North Falls Offshore Wind Farm Ltd – EN010119

Section 51 advice regarding draft application documents submitted by North Falls Offshore Wind Farm Ltd

On 24 May 2024 North Falls Offshore Wind Farm Ltd submitted the following draft documents for review by the Planning Inspectorate as part of its Pre-application Service¹:

Drawing Title
**Work Plans -
 Key Plan (Offshore)**

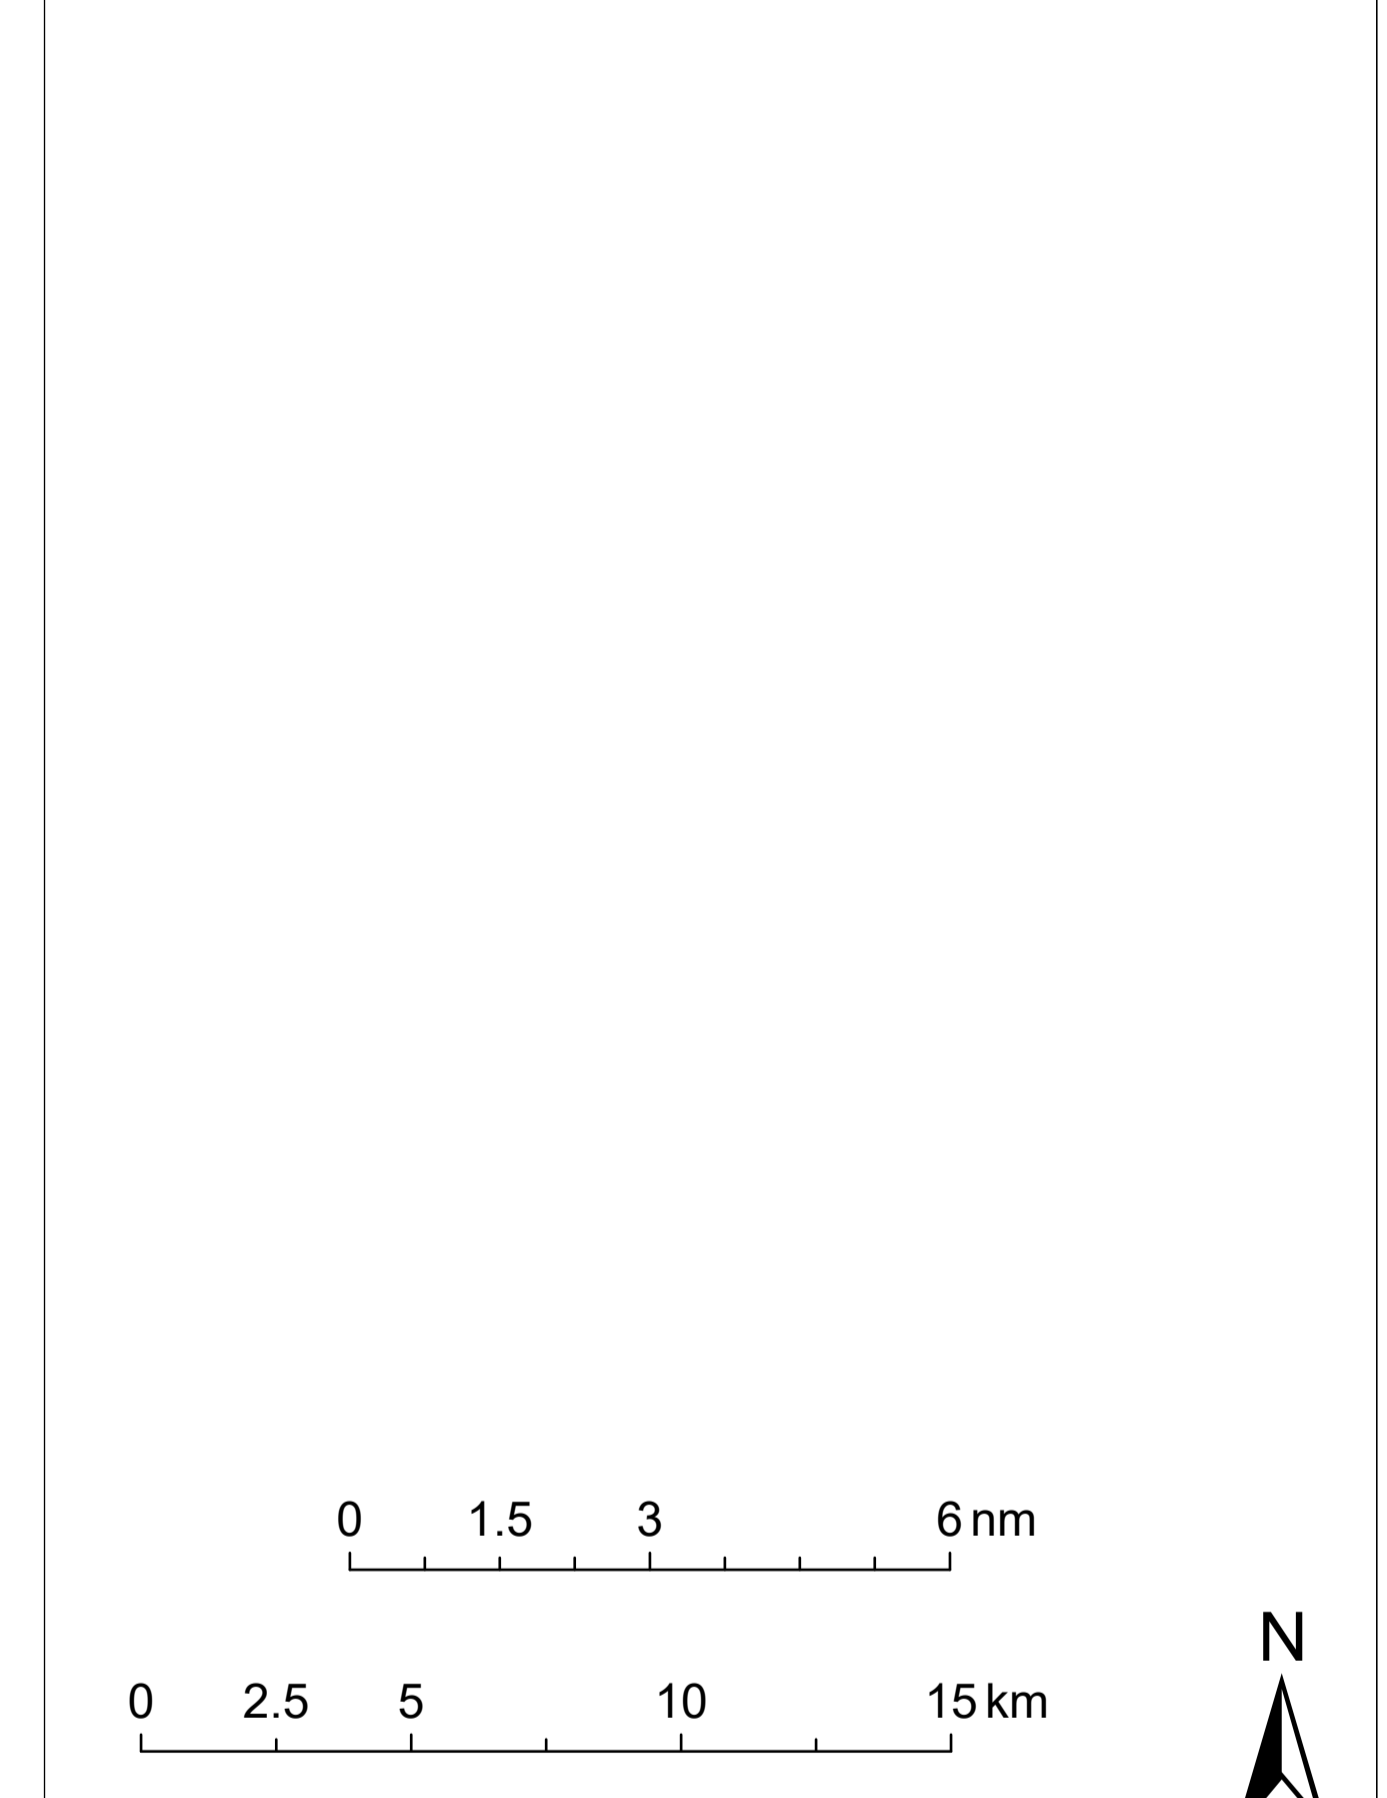
Plans – Onshore & Offshore Work Plans	
Ref.	Comment or query
5.	The applicant is advised to provide a full-page key plan on a separate sheet within each set of plans. This would be in addition to the key plan which is inset into each sheet.

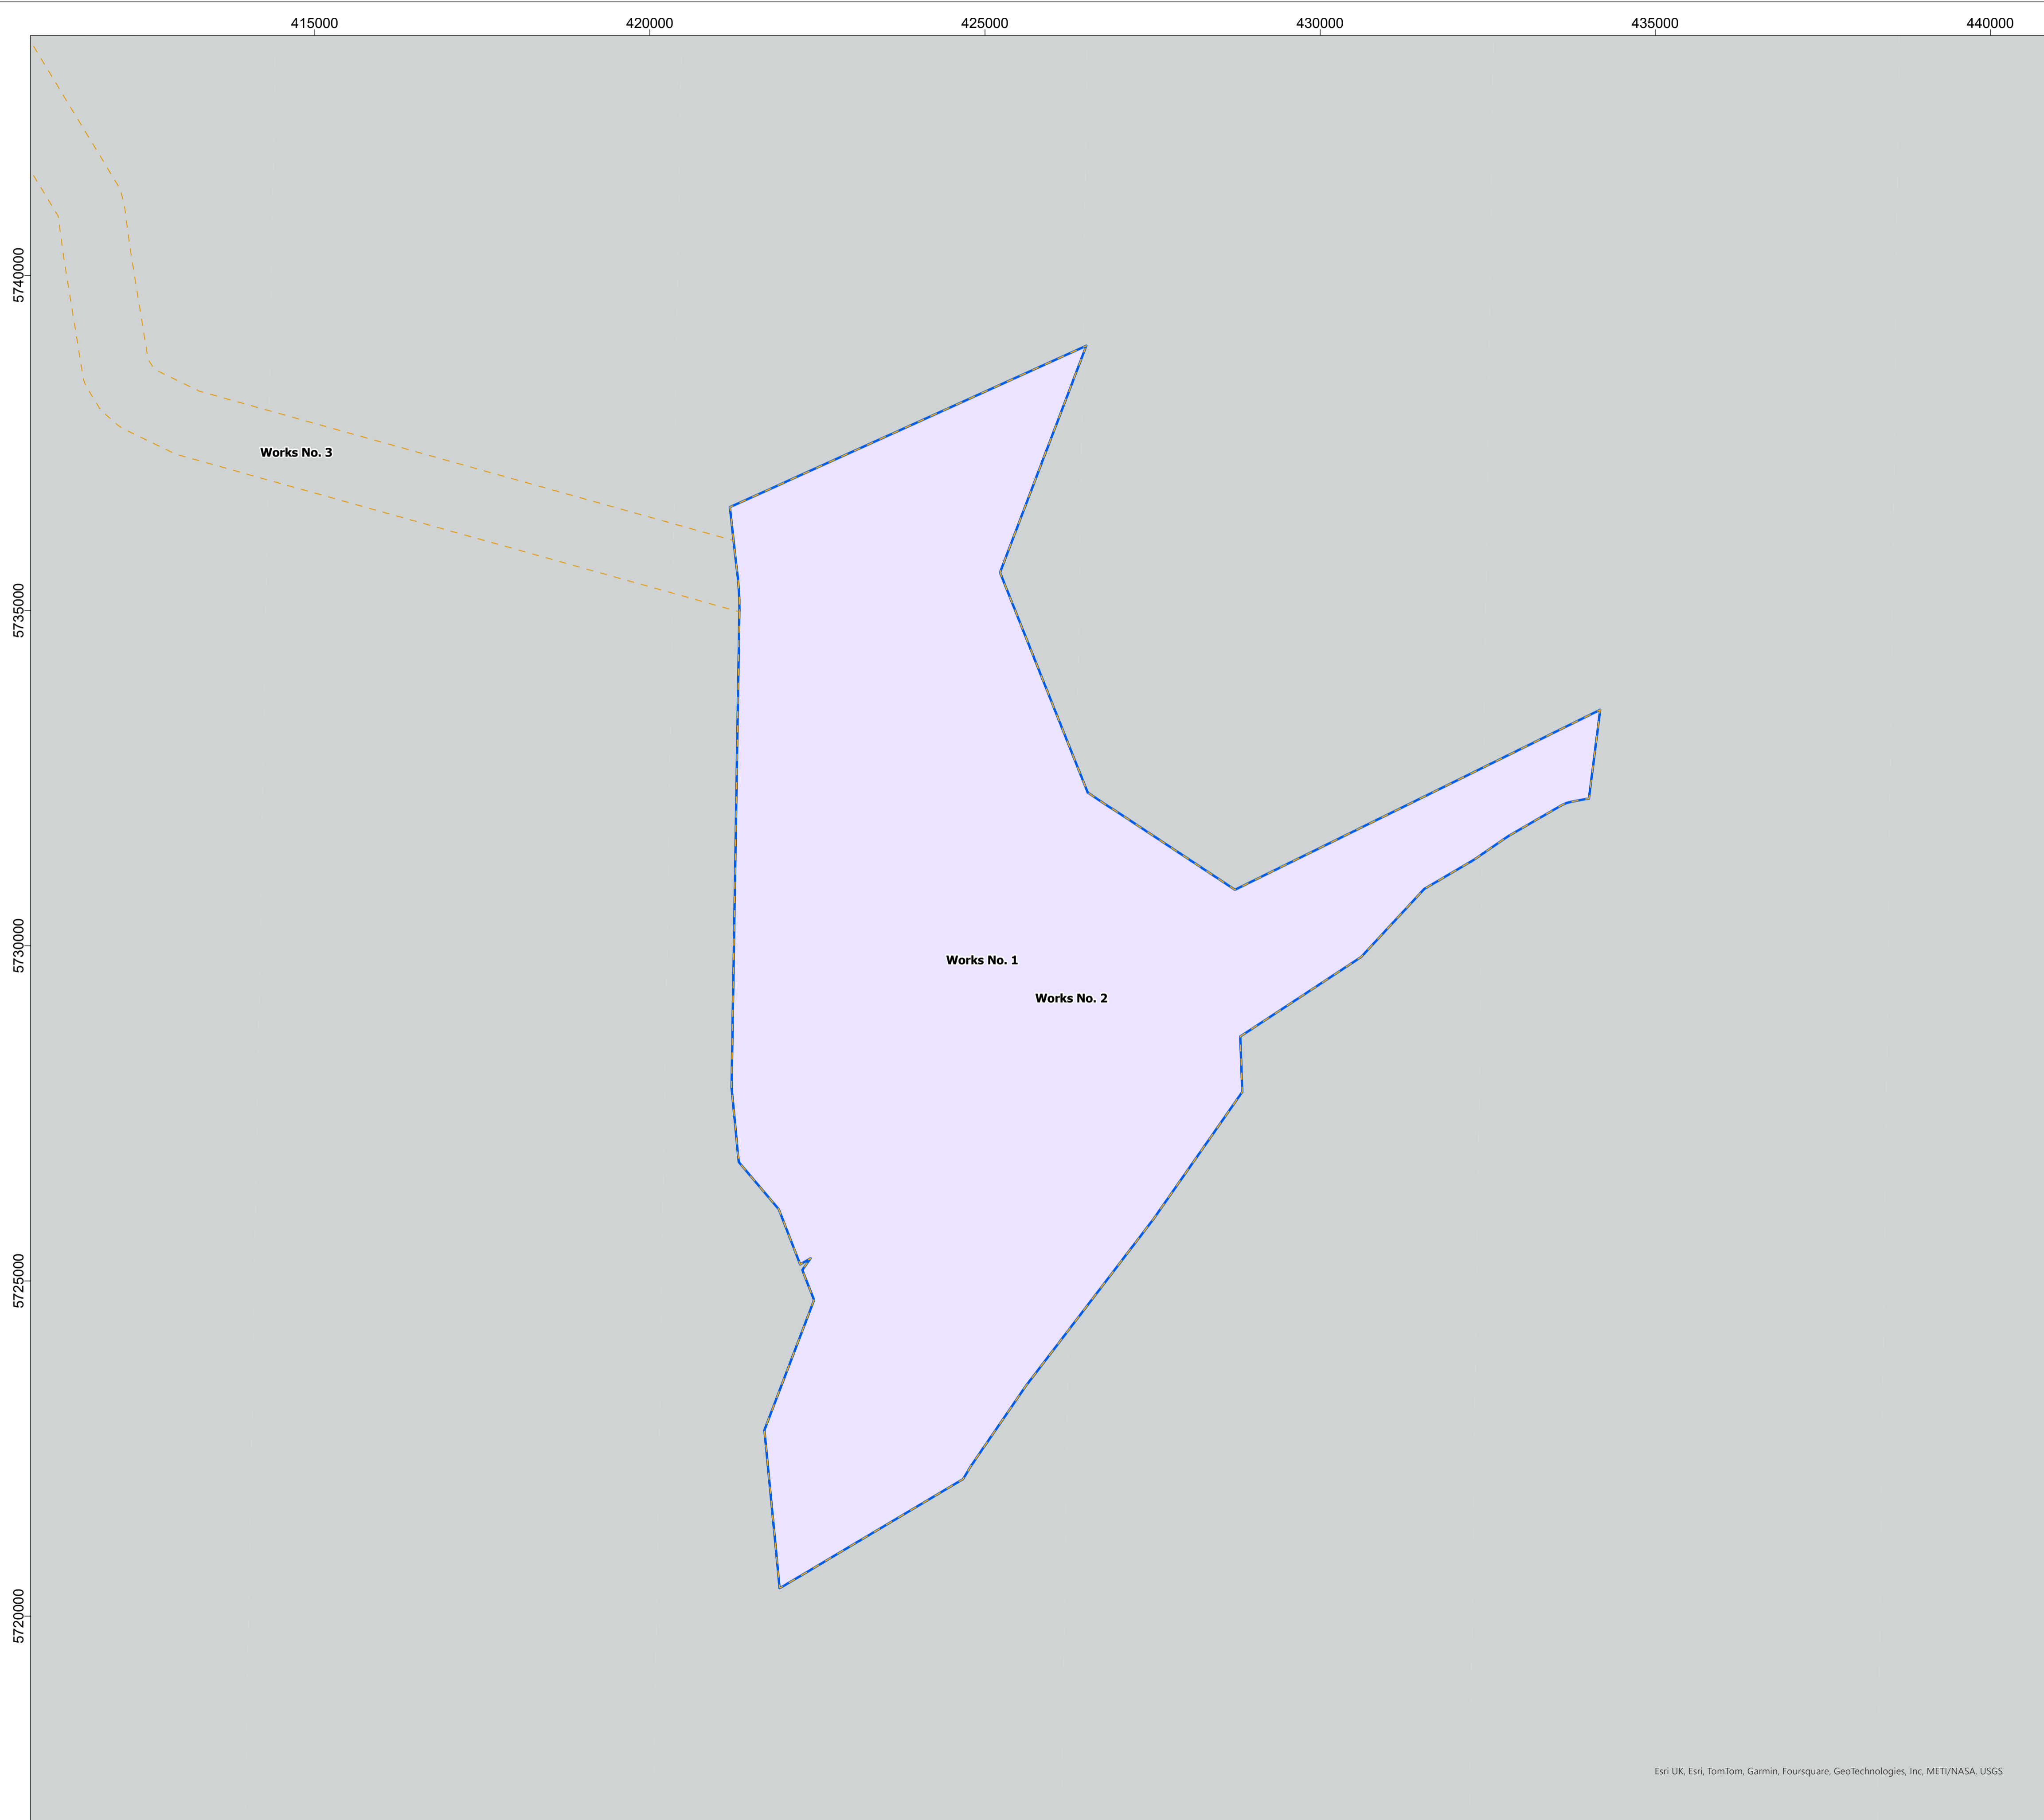
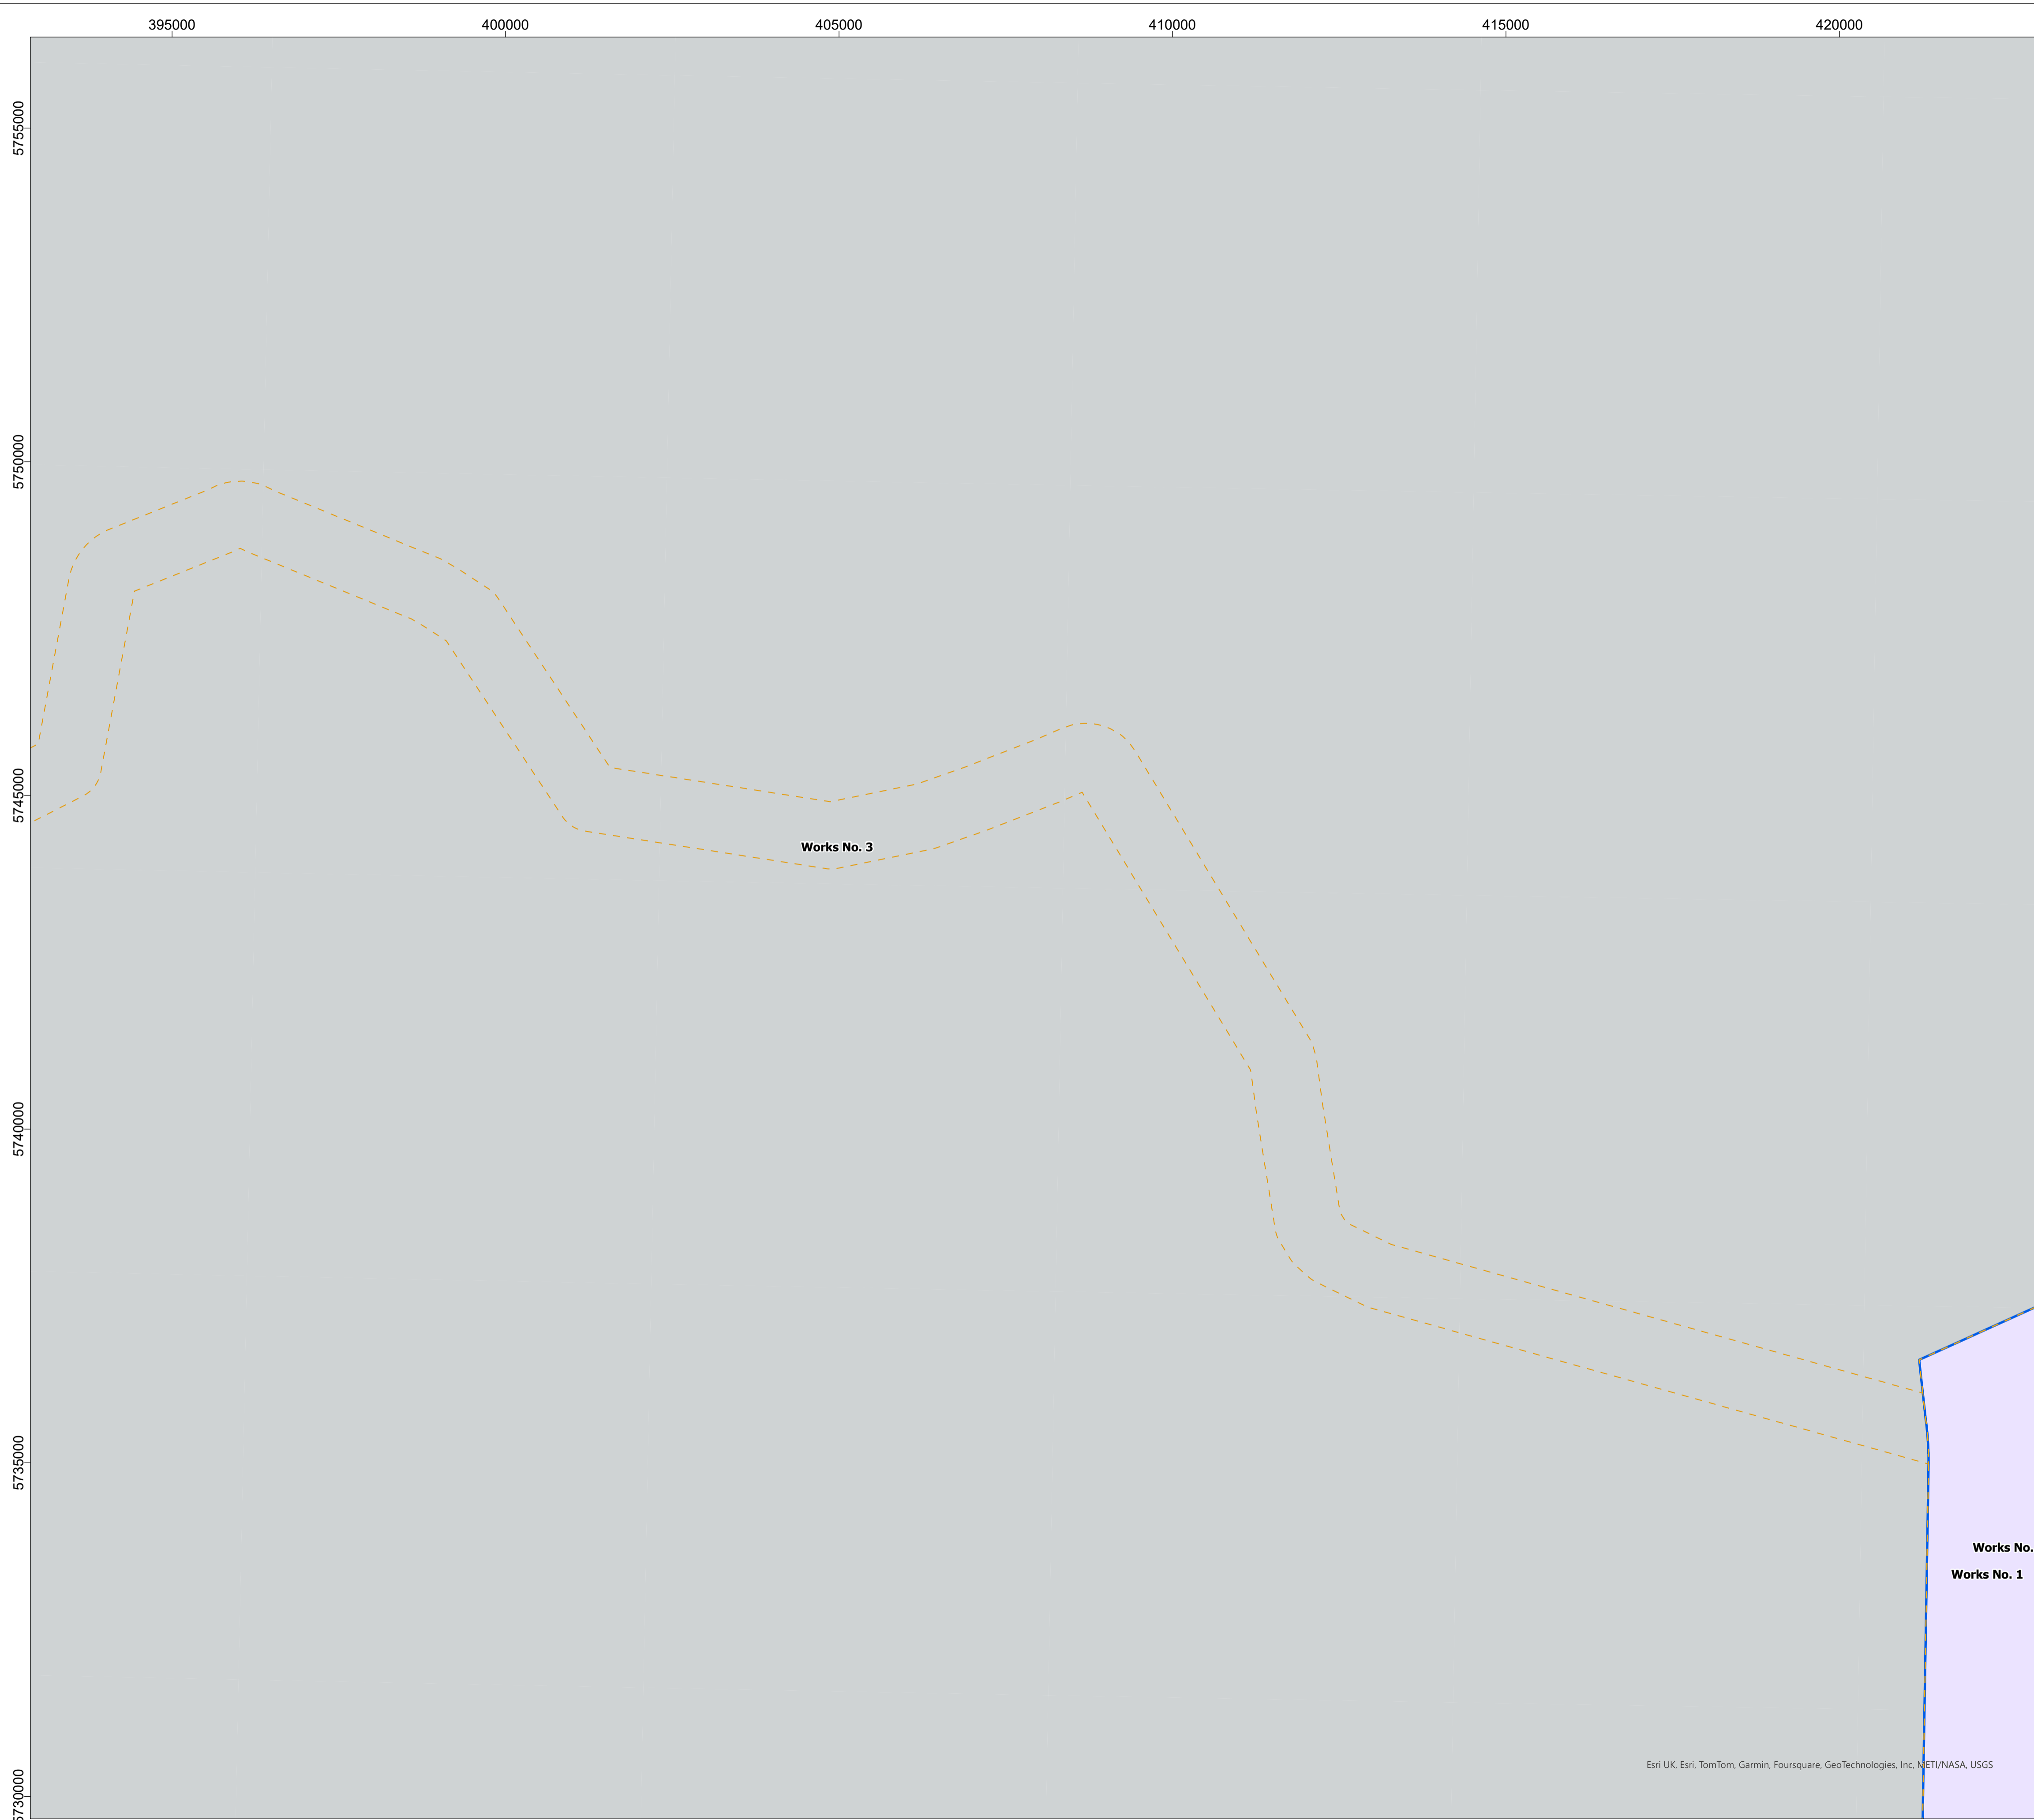
Offshore plans		
Ref.	Plan ref	Comment or question
11.	Works No.4A	Within the Legend an abbreviation is used 'HDD' that is not explained. For ease of understanding, the Applicant may wish to consider using the full term rather than an acronym.
